ENG-SF21021-R1-FDR.pdf Markup Summary

Subject: EPC ENG Review
Page Index: 1
Date: 7/6/2021 8:29:53 PM
Author: dsdrice
Color: ■
Layer:
Space:
Page Label: 1

Sand Creek Impro CL-PR

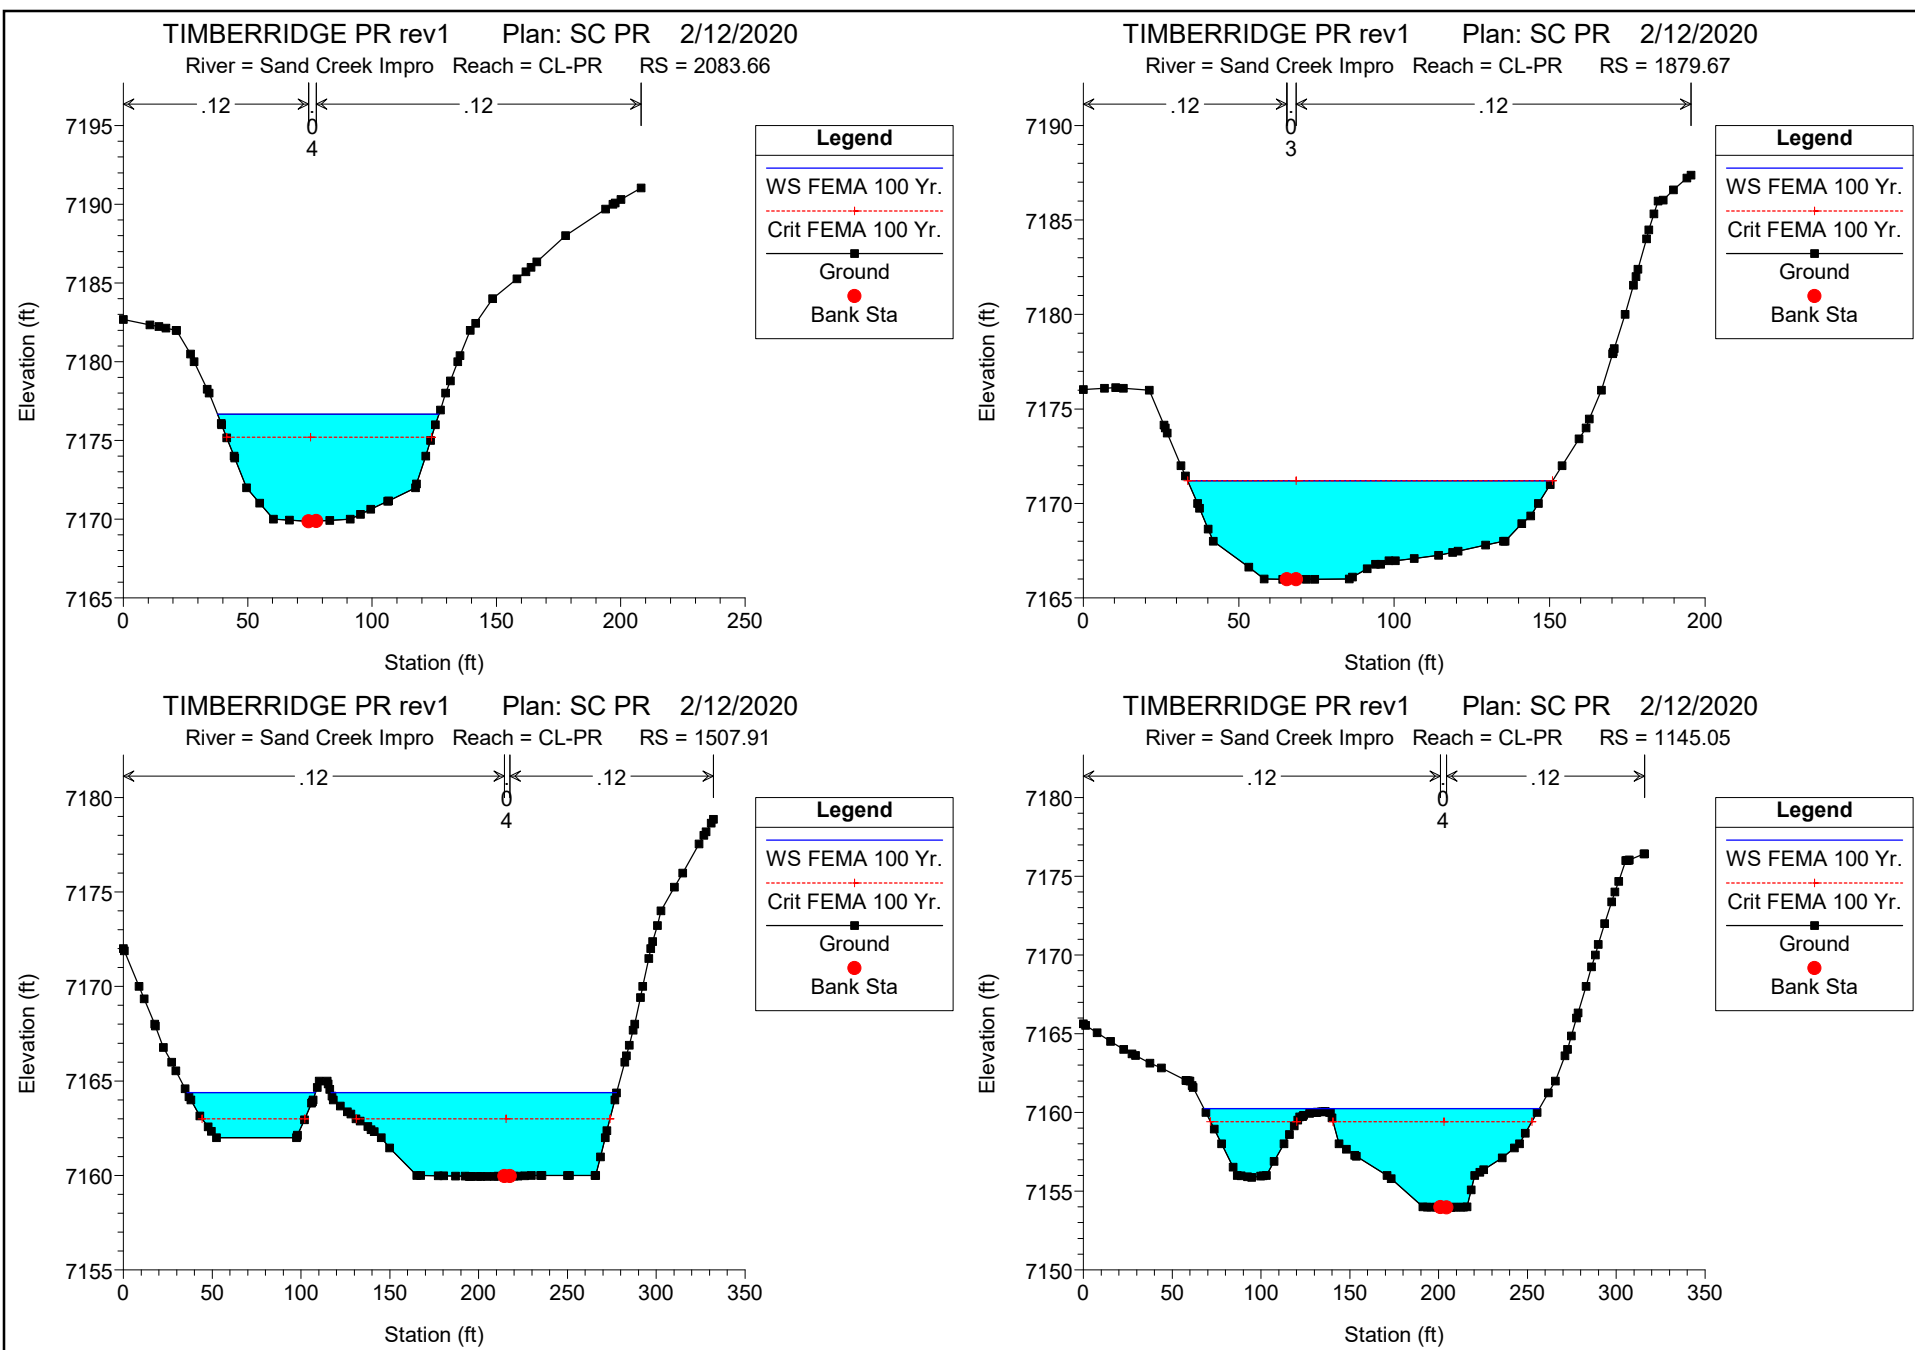
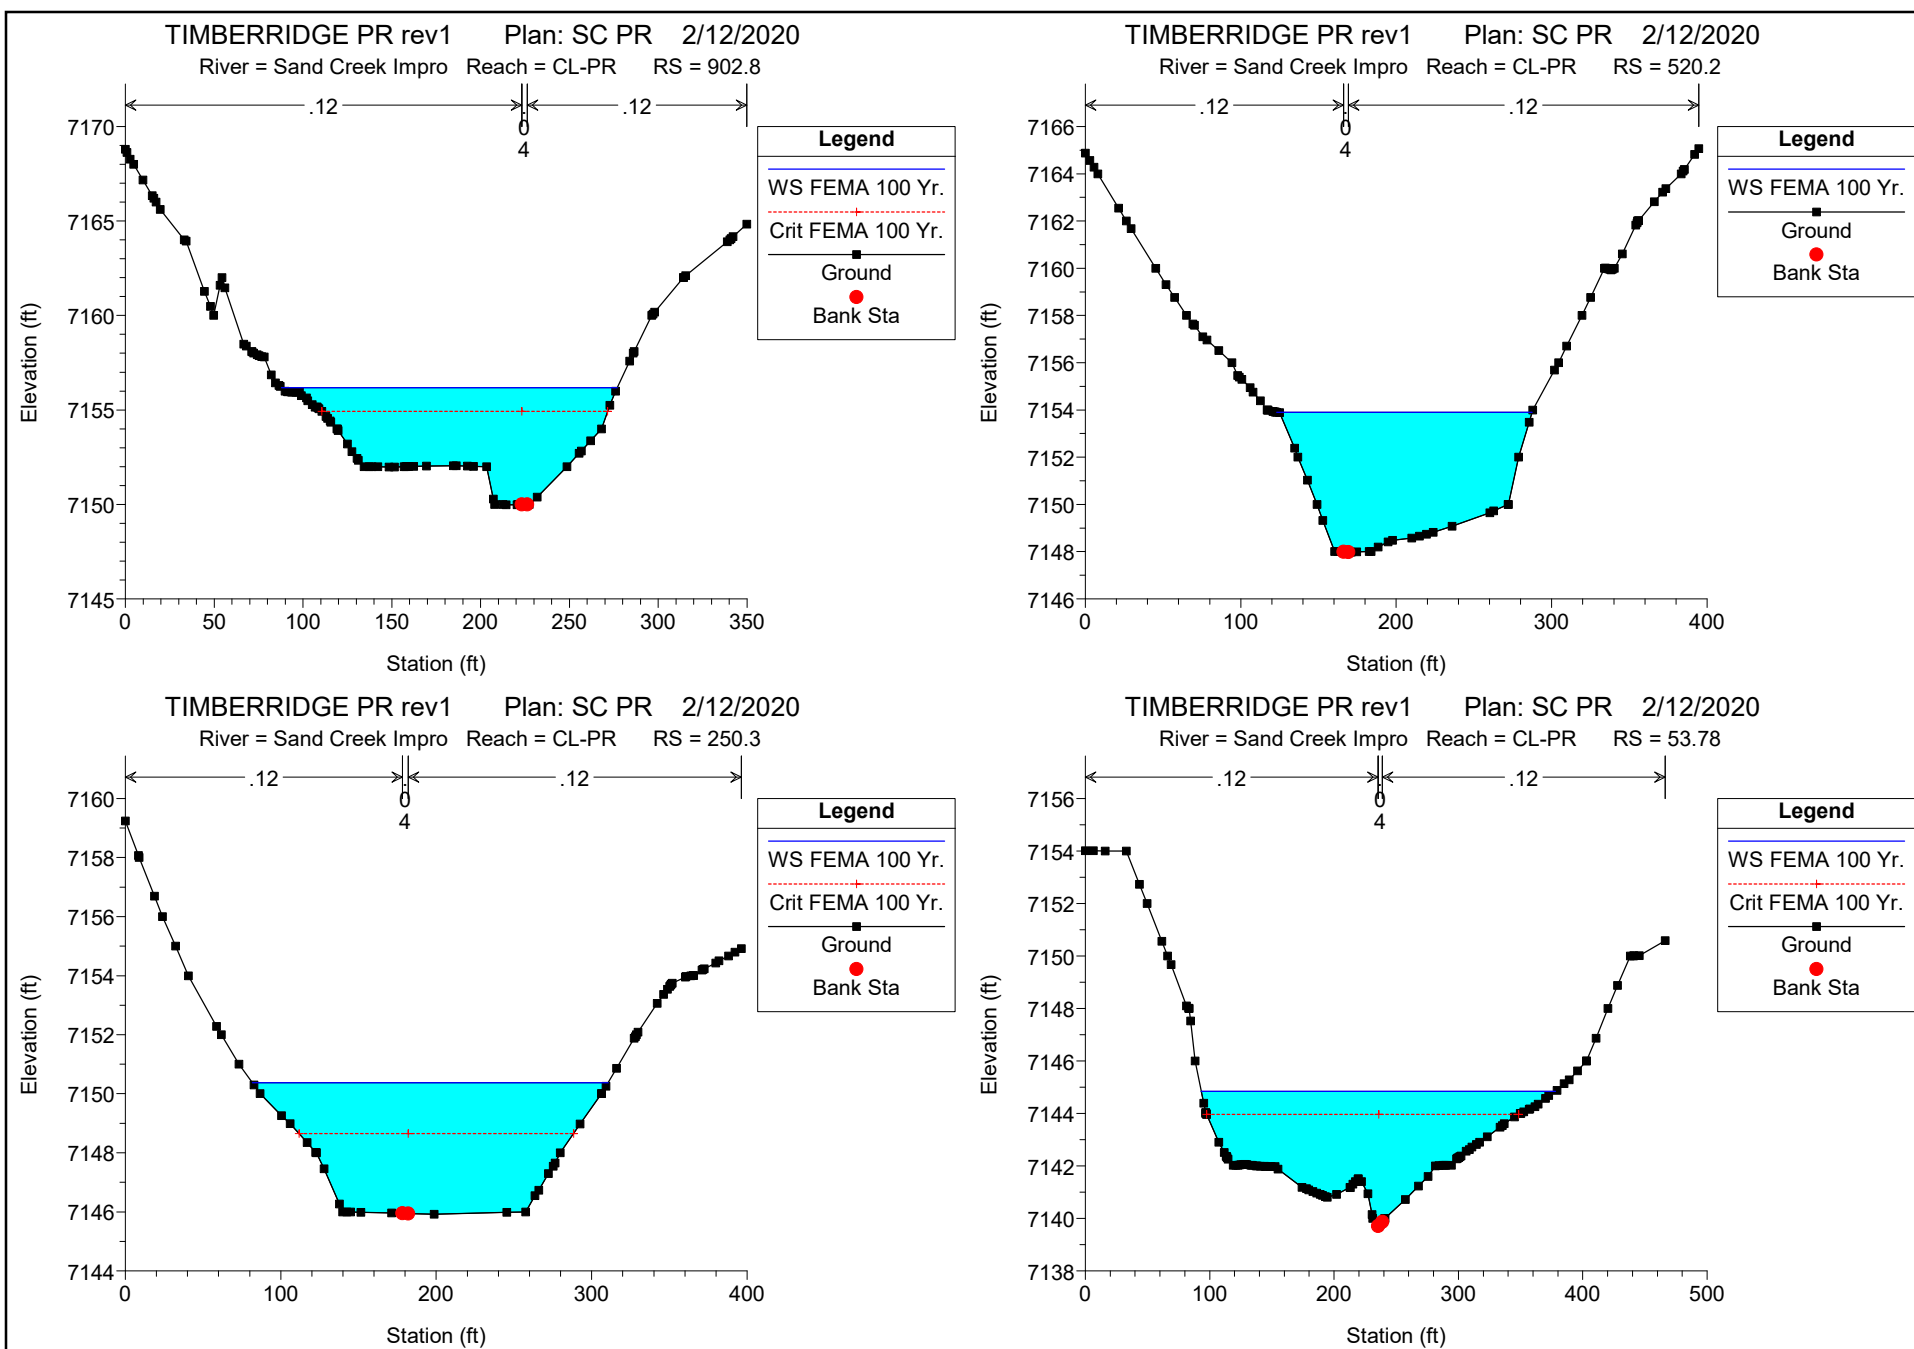
This is next to Lot 13 - if the channel is anticipated to drop 5' in this location additional protection is needed.

How did the channel drop 5 feet? If this model is "future, post-erosion, it needs to be labeled as such. Do the check structures allow for 5' of erosion?
